Application No: BR/39/26/PL
Site Address: Bognor Regis Sports Ground Hawthorn Road Bognor Regis PO21 2UW
Description of works: Replacement of existing 1.8m high fence panels along the perimeter of the sports ground (north and east) with a new 3m high green metal twin bar fence. This application is in CIL Zone 4 (Zero Rated) as other development.

Thank you for your internet representation made on 16th May 2026 which has been recorded as an objection with the comments as follows:

PROPOSED NYEWOOD LANE FENCE ELEVATION (125 Lm)
SCALE 1:200

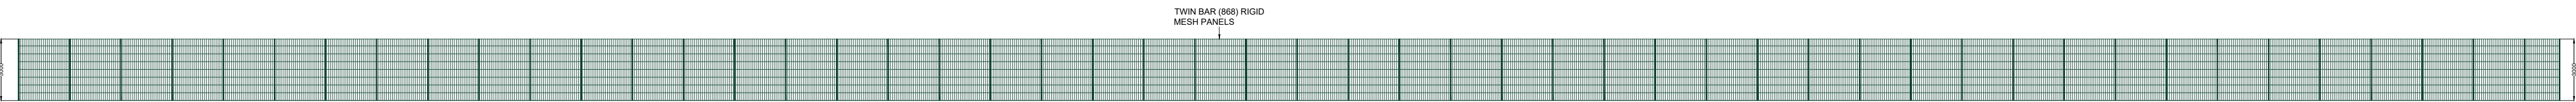
I do not have an objection to the type of open fence that has been proposed as long as it remains open i.e. does not have the netting on in the same way the North Side does on Hawthorn Road. I do object to the height of the fence on Nyewood Lane as it is not in keeping with the residential area. 3m is far too high. I have lived at this address for 29 years and I have never seen a ball in the road near my property so do not agree that the fence needs to be this high to prevent the odd (if any) balls from going over the fence on Nyewood Lane.
